NSW RURAL FIRE SERVICE

Your reference: SSD 6917 MOD1
Our reference: D16/4003

Modification to Oakdale South Industrial Estate - Concept Proposal and Stage 1

**Bushfire Protection Plan**

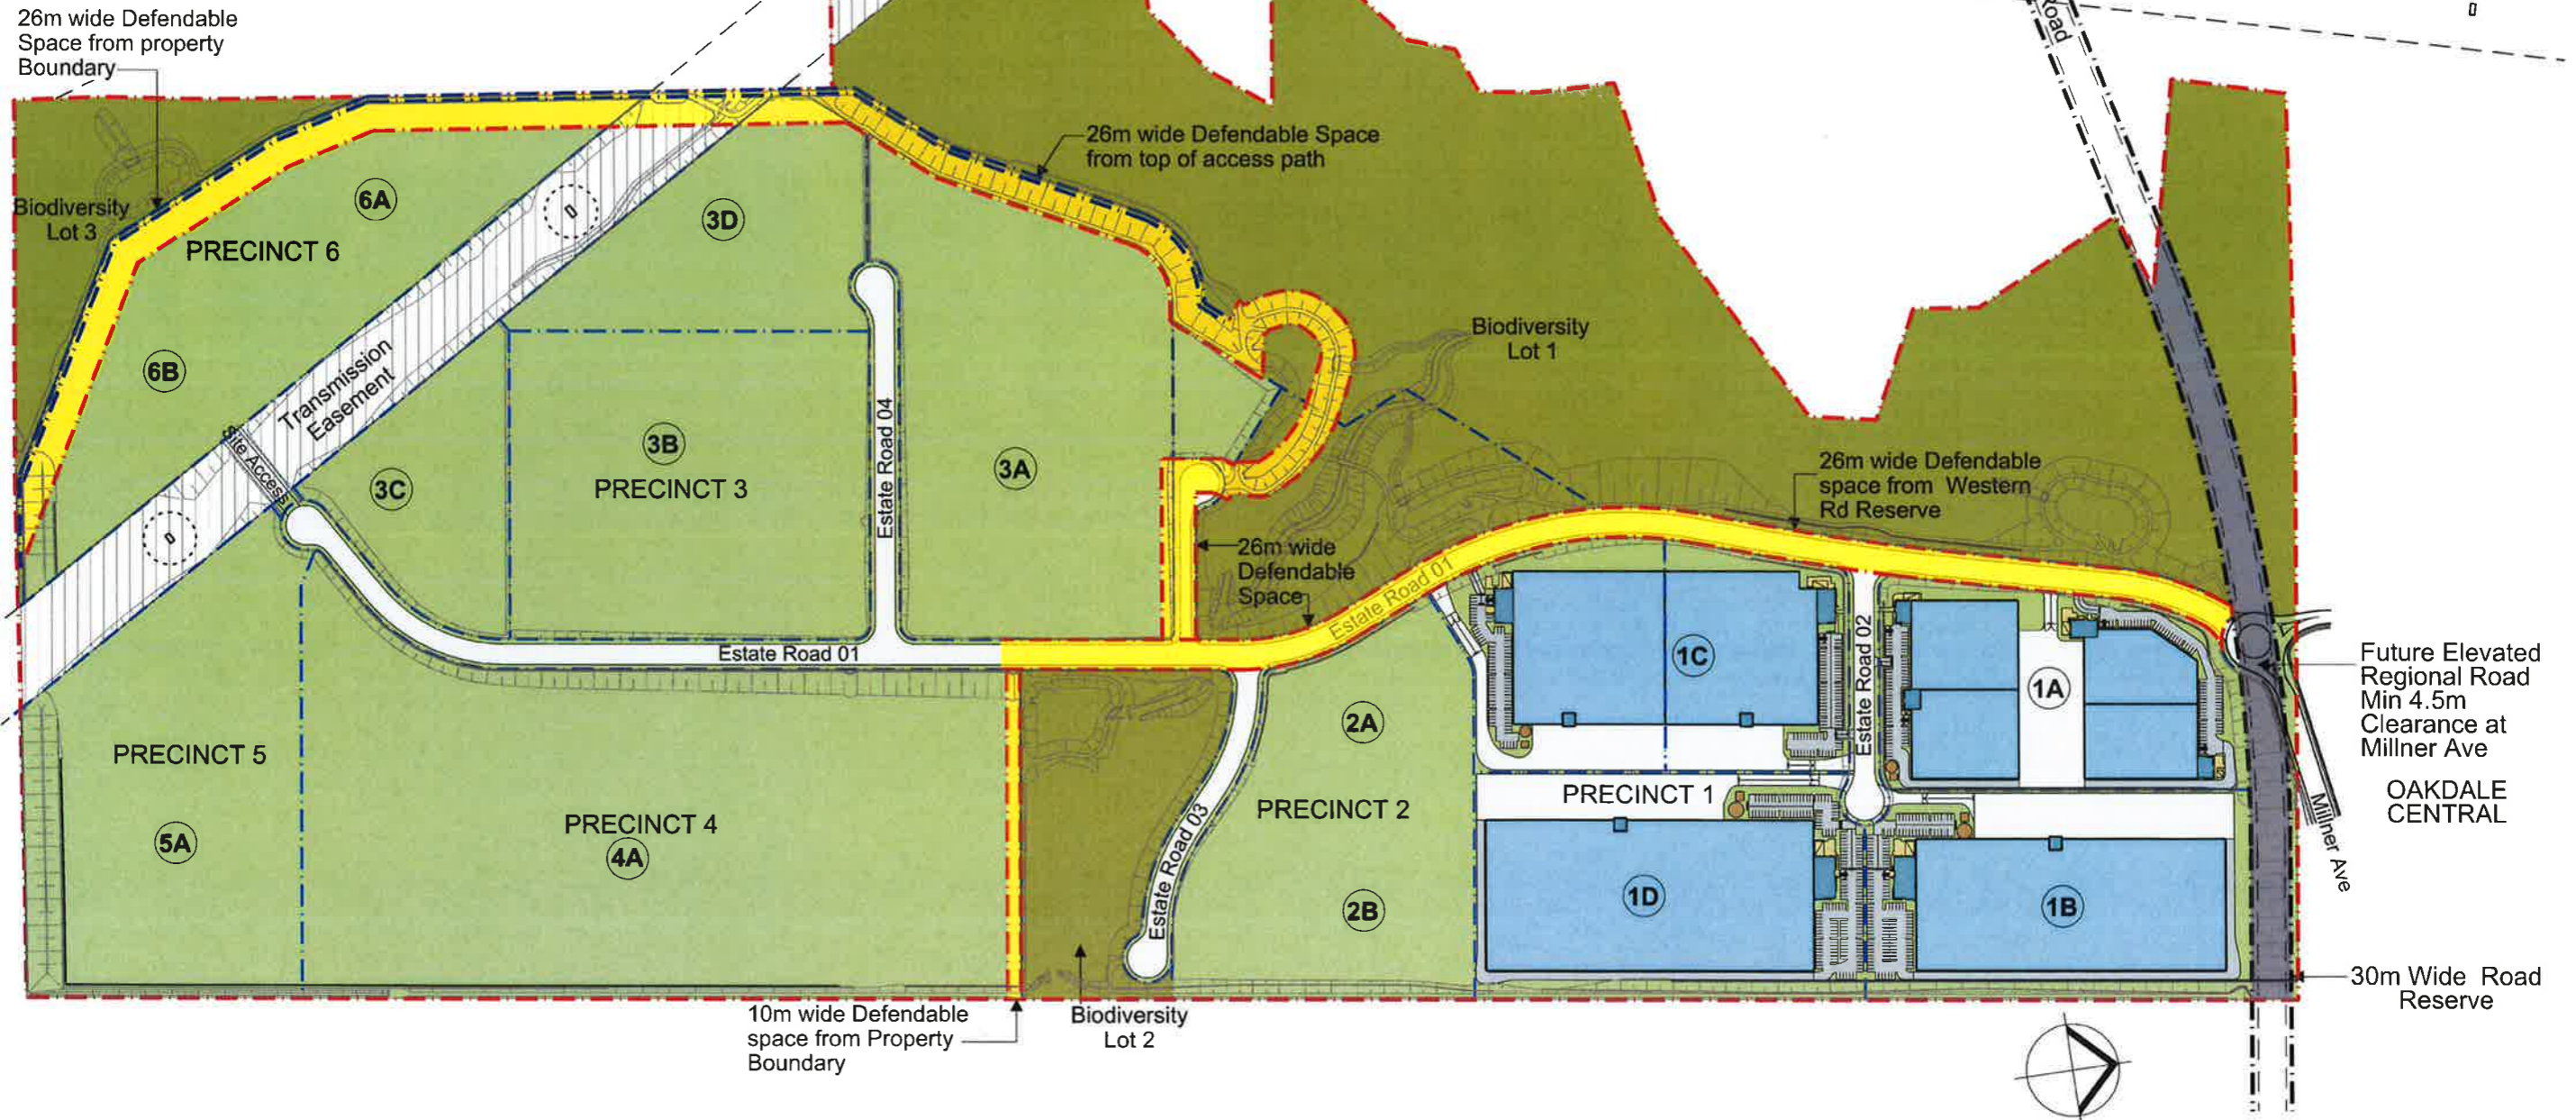
1. A 26 metre asset protection zone (APZ) is to be provided along the eastern boundary of Biodiversity Lot 1 and the northern boundaries of Biodiversity Lot 2 and Lot 3 and a 10 metre APZ is to be provided along the southern boundary of Biodiversity Lot 2 as shown on the plan titled *Section - Modified Estate Masterplan showing the minimum Defendable Space widths to the future buildings* prepared by Australian Bushfire Protection Planners (September 2016). APZs are to be maintained in accordance in *Planning for Bush Fire Protection 2006* and the NSW Rural Fire Service's document *Standards for Asset Protection Zones*.
